Ribble Valley Borough Council
Housing & Development Control

Planning Application No: 3/2022/0192

Proposal: Proposed demolition of existing garage and conservatory and erection of new side and rear extensions along with loft conversion to include dormer to rear elevation.

Location: 11 Risedale Drive Longridge PR3 3SA

Proposed Site Plan

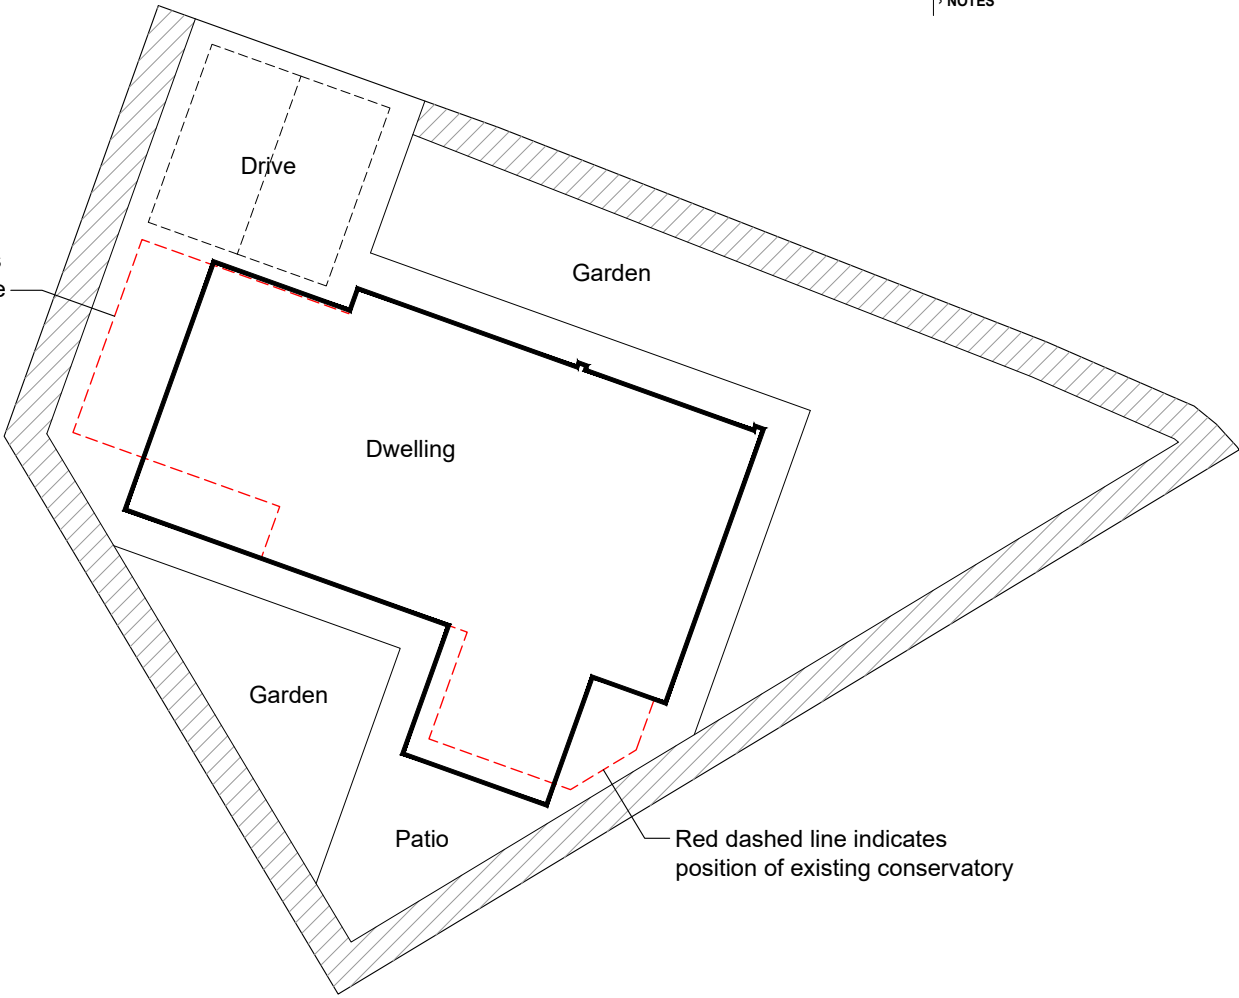
There is no parking plan submitted. Providing the two parking spaces required by parking standards can be provided within the curtilage of the drive then there is no objection to this proposal on highway grounds,

1. The parking areas must be constructed of a bound porous material and created before first occupation up until the lifetime of the dwelling existing in its proposed state. Reason: To ensure that satisfactory parking is provided before the dwelling hereby permitted becomes operative
